Your Ref: OWPC23887
Our Ref: P/53/19/L 05-06-2019
Please ask for:
Maria Tomalova

Listed building consent for the demolition of modern side extension & 2.25m of boundary wall.

Inglenook Hotel 253-255 Pagham Road Pagham

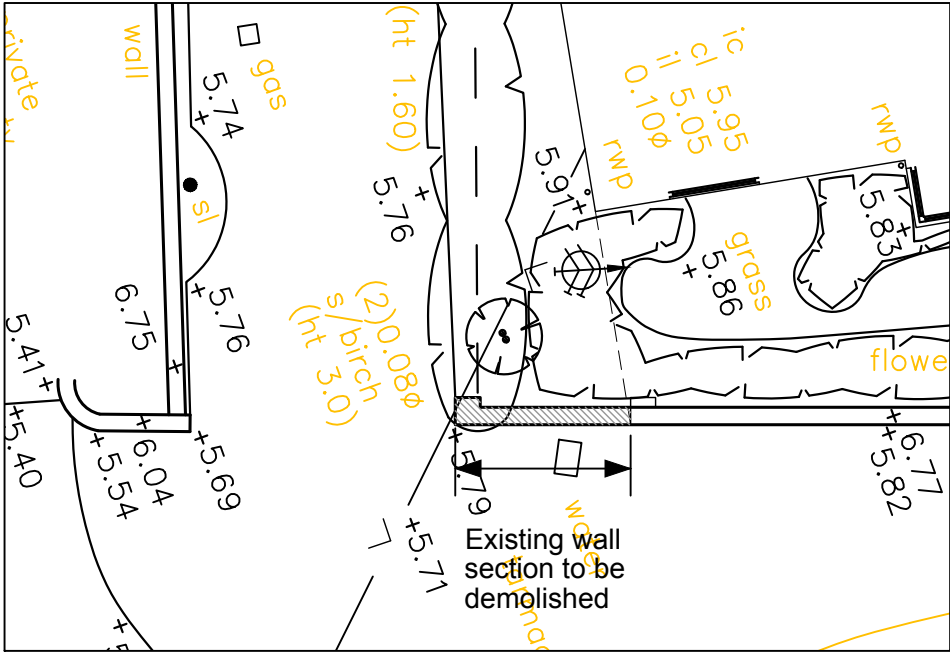
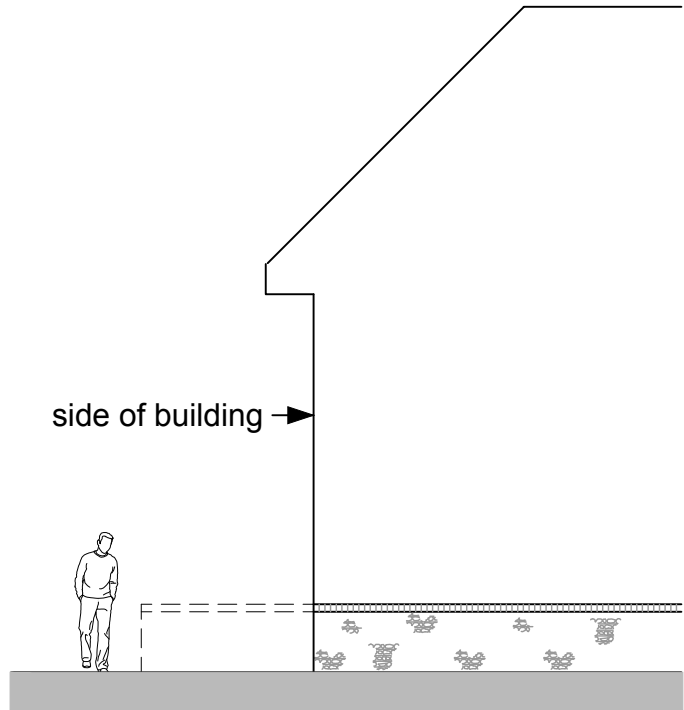
Regarding the application to demolish a wall & chair store at the Inglenook Hotel, we feel that we must object for the following reasons:

- 1. The resulting entrance created if this application is allowed will be very restricted, and will surely still be difficult for large service and emergency vehicles to access, particularly if the Inglenook car park, which it crosses, is busy (as is often the case).*
- 2: Visibility to the left will be very restricted to the left for any vehicles exiting the development/car park. Delivery vehicle and customers vans & cars are always parked in the lay-by to the left, meaning you have to pull well out into the road to get a clear field of vision.*
- 3: Presumably there will be some loss of spaces in the existing car park, meaning even more vehicles will be trying to park on the already very congested Pagham Road.*
